Our Ref: AB/136/18/L
Your Ref:

Planning (Listed Buildings and Conservation Areas) Act 1990 (as amended)

Application for Listed Building Consent for Alterations, Extension or Demolition of a Listed Building

Development Replacement timber and glass conservatory structure within outbuildings in yard / garden.
Location 2 Kings Arms Hill Arundel

BLOCK PLAN SCALE 1:200

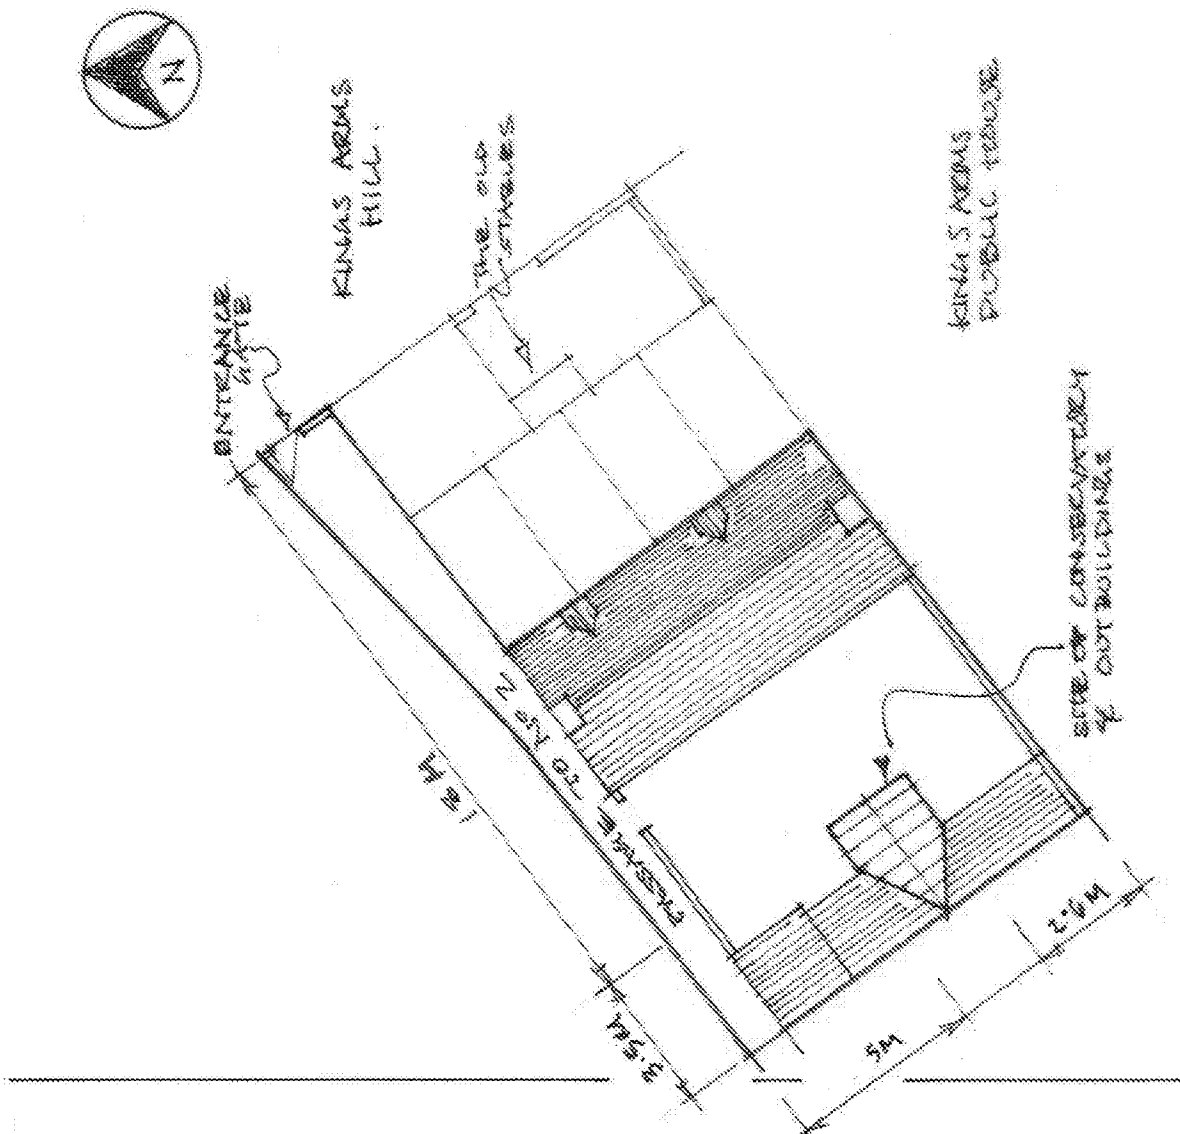
Inconsistent: The existing block plan is inconsistent with the design & access statement as it claims that the existing conservatory has a 5 pane glass roof but the block plan is showing 7. Please confirm which is correct and amend as necessary.
